From: Biazar, Shahab
Sent: Sunday, July 20, 2014 9:12 AM
To: Martin J. Garcia (martin@anchoreng.net)
Cc: Ortiz, Monica; Sims, Timothy E.
Subject: Erosion And Sediment Control Plan For Garcia's Kitchen (J13E096)

I have the following comments on the submittal for Garcia's Kitchen's Erosion & Sediment Control (ESC) Plan, (J13E096):

EROSION CONTROL PLAN

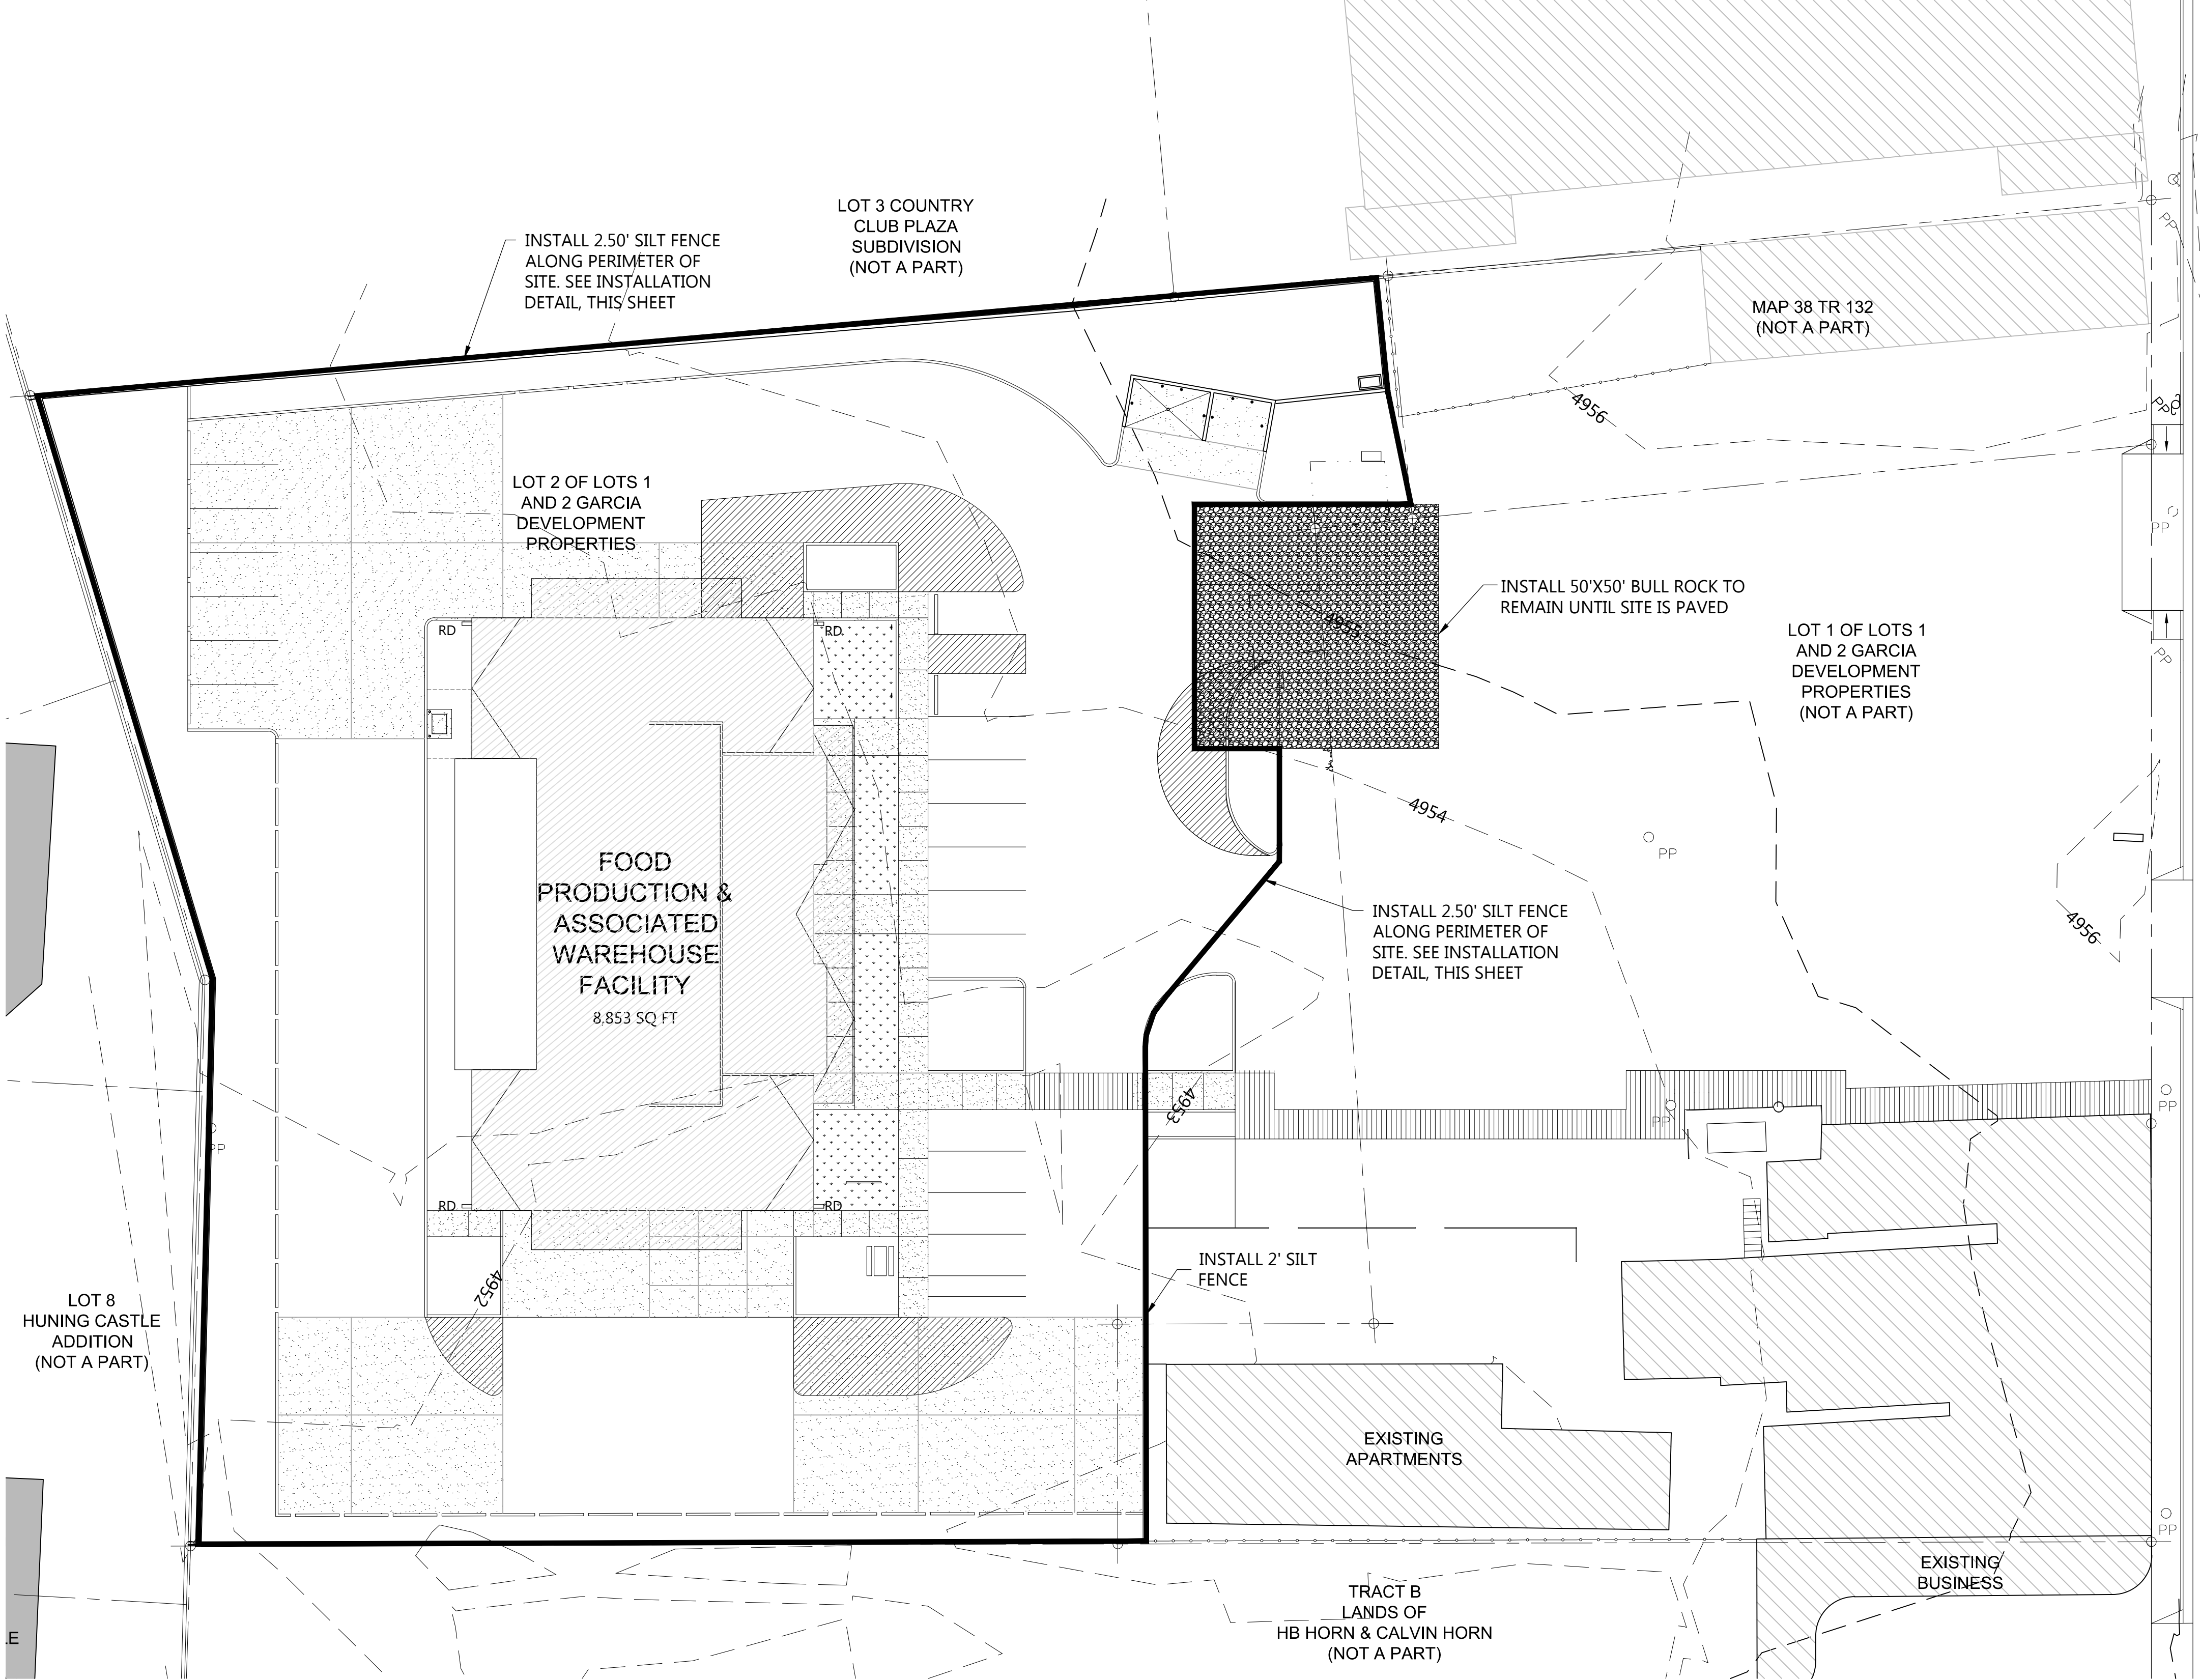
- _Sing posting location should be shown on the plan (sign to be visible from public street).
- _All plans should be signed and stamped.
- _Include Legend and Drawing Scale.
- _Show staging and concrete washout area.
- _Include a note that "Project is required to maintain a regiment of street sweeping and clean up measures in the event of track out to minimize and prevent off site conveyances during construction."
- _Include all BMP details on the plan. If BMP details are shown on a separate sheet, please make sure the plan is signed and stamped.
